Planning Officer: Mr S Davis

Planning Application Ref: AL/20/21/PL

Location: Land at Wings Nursery, Lidsey Road, Woodgate, PO20 3SU

Description of works: Demolition of Wings House & erection of 71 No. replacement dwellings (70 net new dwellings), access arrangements, sustainable drainage measures, public open space, landscaping & all other associated works (resubmission following AL/46/20/PL). This application is a Departure from the Development Plan

Appendix 6 - development proposal plan

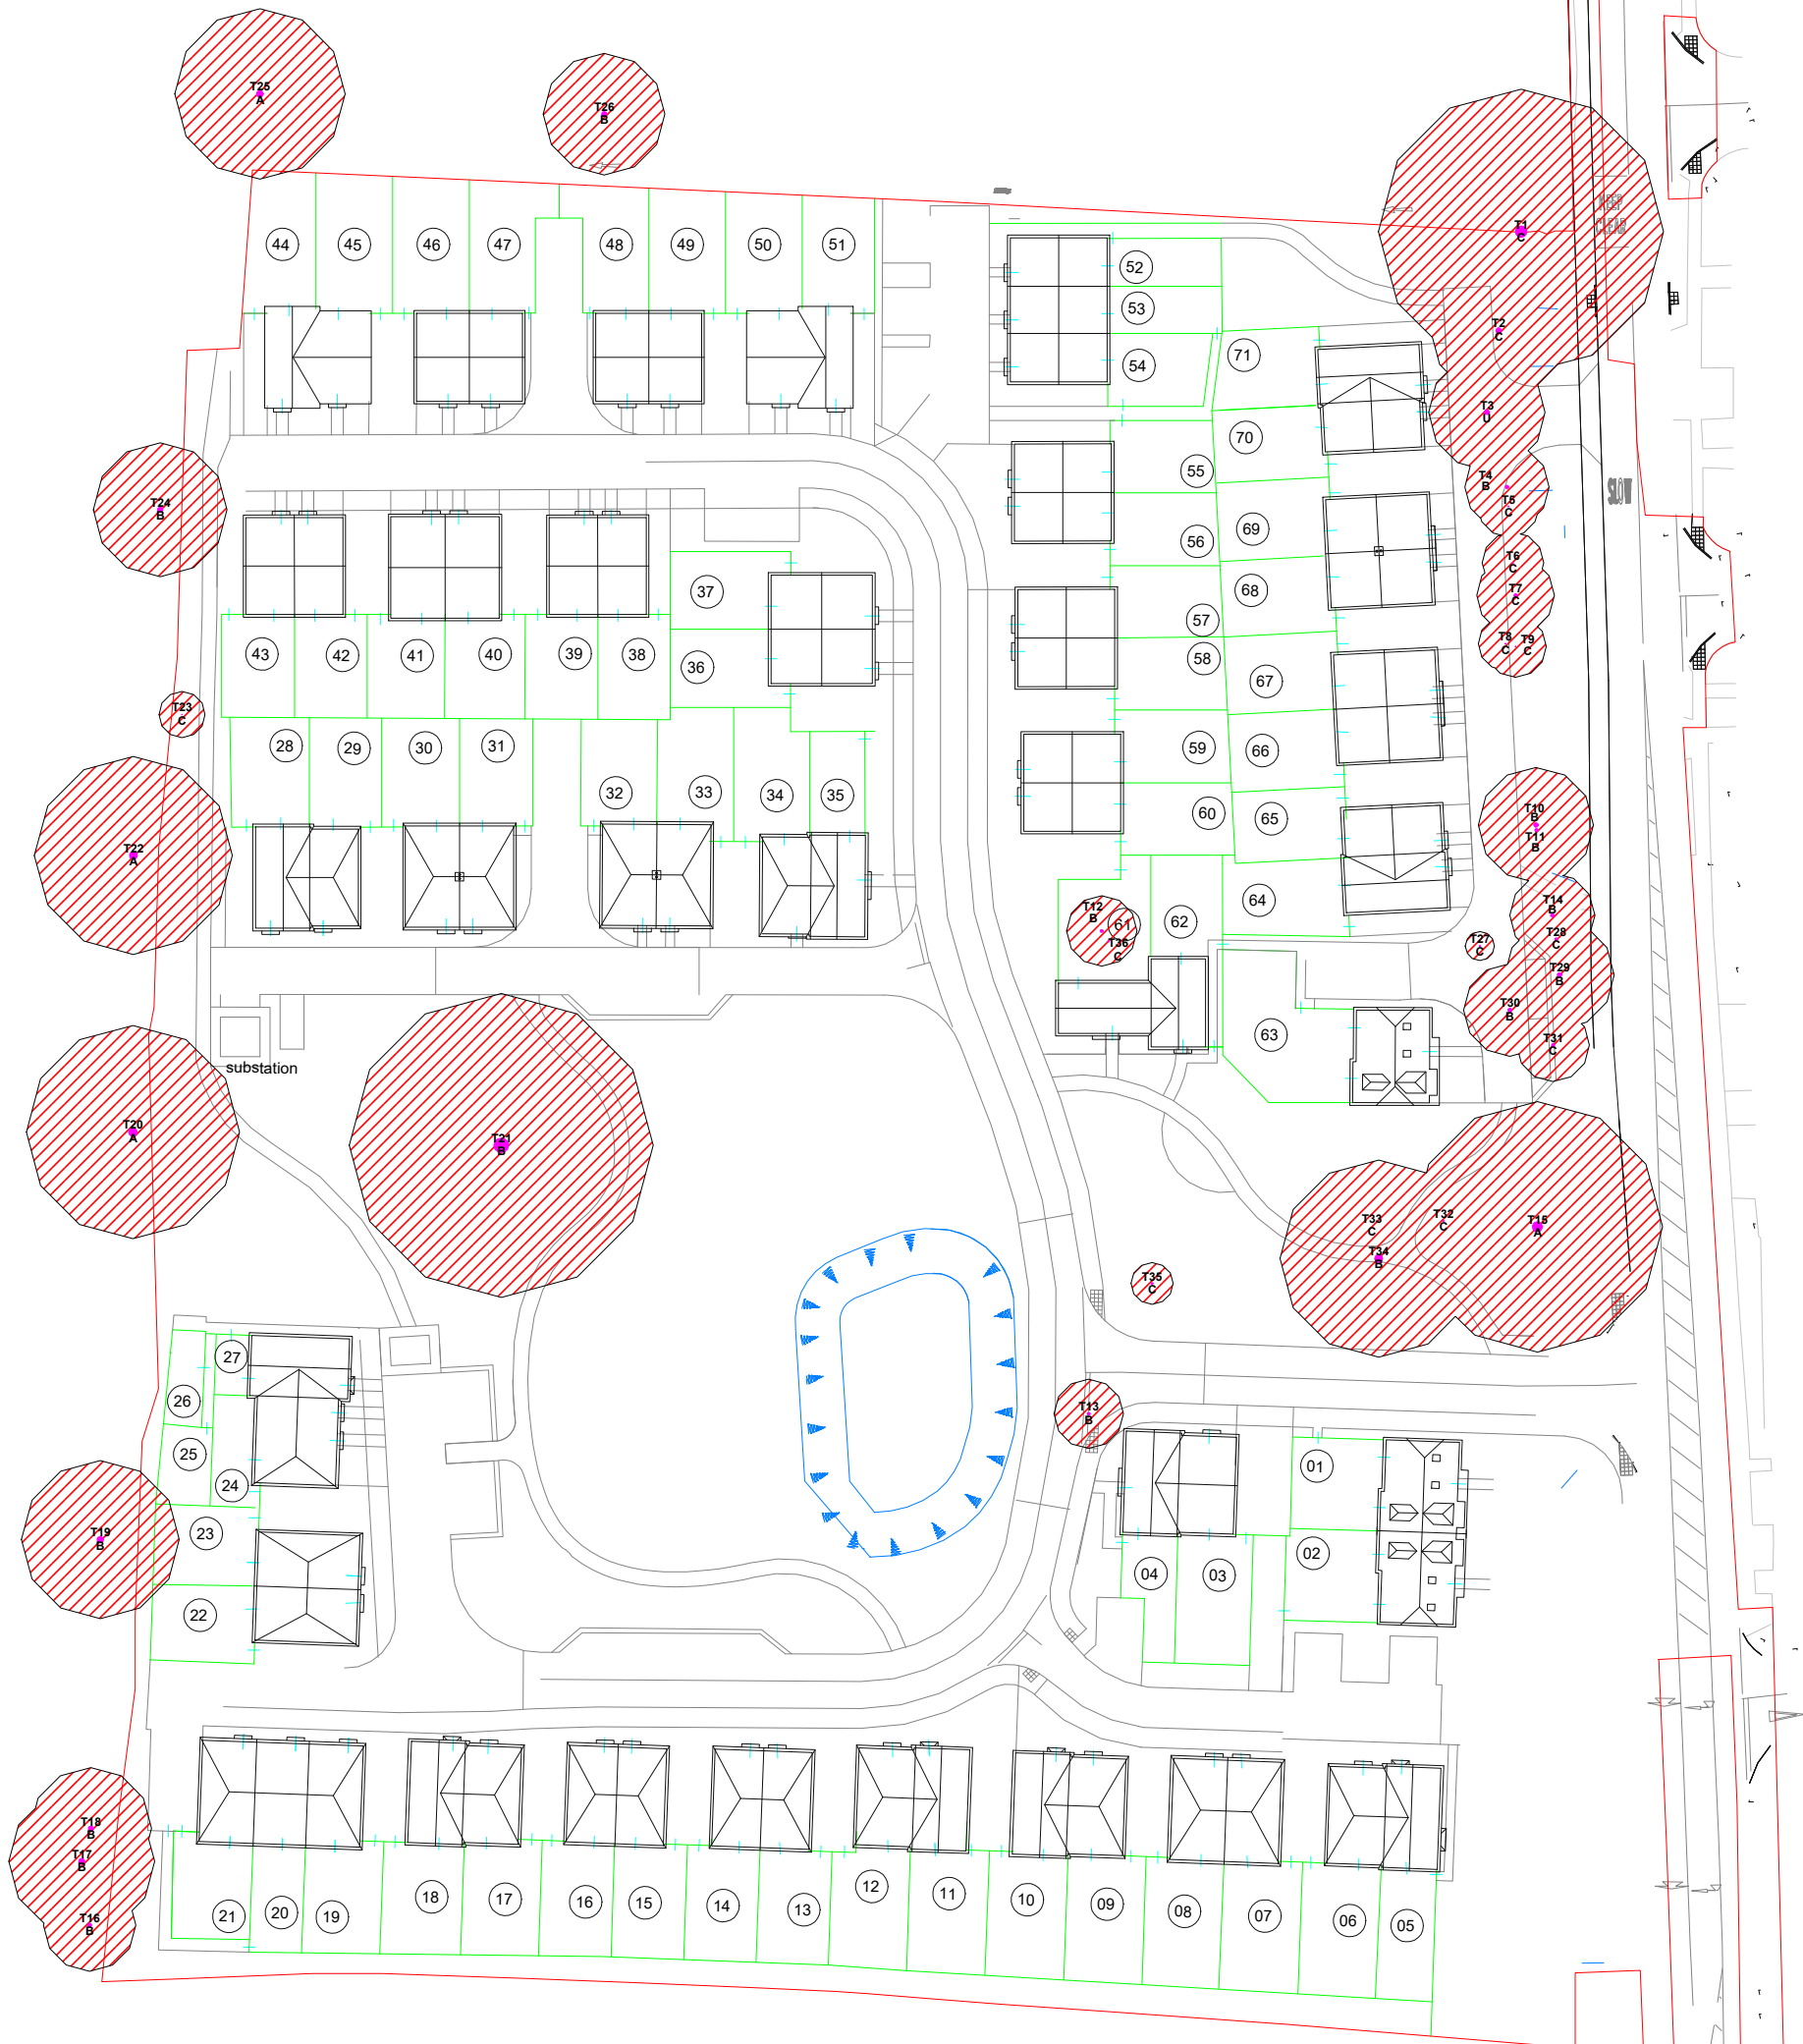
- In order to properly consider the impact of the current layout on existing trees, we must look at both the Development Proposal Plan (Appendix 6) and Tree Protection Plan (Appendix 7). Those show the extent of RPA.

Important: The above plans embedded within the report are based on Proposed block plan 19-121 0003 Rev.1 provided by MH Architects. Those have been superseded by later revisions dated 13/05/2021, although the latter is incorrectly titled as development proposal plan.

- Written assurance required stating that no RPA incursion will occur during works to install/enhance surface water drainage features or foul water apparatus in relation to T1 currently and any other retained TPO tree.

- Re-align footway to take it outside of T15 high value oak's RPA. Please also show position of diverted surface water drain on west side of tree relative to RPA. An additional 2m buffer must be shown on the plan so we can be confident those works will not impact directly on the tree.

- Create a semi-wild area that captures high value oaks T21 – T20 (and possibly T22?). The latter has veteran tree characteristics which demands a 15metre RPA. Such an area, together with removal of the footway within RPA - will prevent any deleterious hazard abatement pruning that would inevitably diminish its landscape and ecological potential, as well as improving opportunities for biodiversity gain.

- Re-align footway to take it outside of T20 & T22 high value oaks' RPA.
- T25 high value oak remains a heavily overbearing feature of the gardens (plots 44 & 45) and is to be partially obscured by built form. Reconsider plot configuration at NW corner to minimise negative impact and incorporate tree's visual amenity into development. It ought to be another focal point and not destined to be a concealed nuisance.
